Howerton Services, PLLC
License # P-1716
3513 Cathedral Bell Road
Raleigh, NC 27614
(919) 270-3460

Subject: 3418 Matthews Mill Pond Road
Angier, NC 27501
Pole Barn Framing Modification Letter
Harnett County Permit #: BRES2403-007

# STURDI-WALL® PLUS ANCHOR BRACKETS

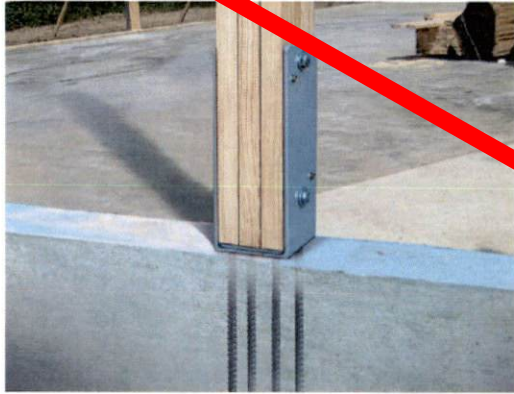
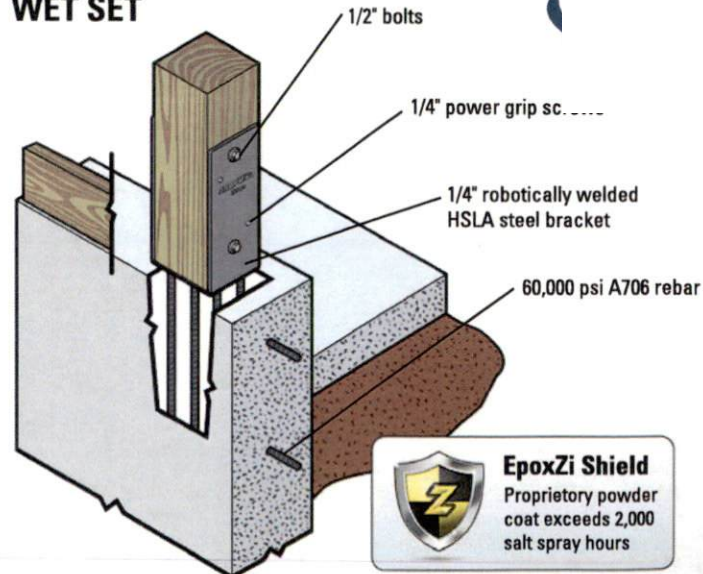
Based on the request of the Contractor, the Pole Barn Post footings will be modified. My assessment and recommendations are as follows:

- The Contractor would like to use post brackets on the 6x6 treated posts in lieu of embedding the 6x6 posts into the concrete footings. The Contractor will use SWP66 Sturdi-Wall Anchor Brackets to attach the 6x6 posts to the concrete footings. The SWP66 brackets are an acceptable alternative.

The modified post attachments for the Pole Barn posts meet all the requirements of the 2018 North Carolina Building Code for Residences.
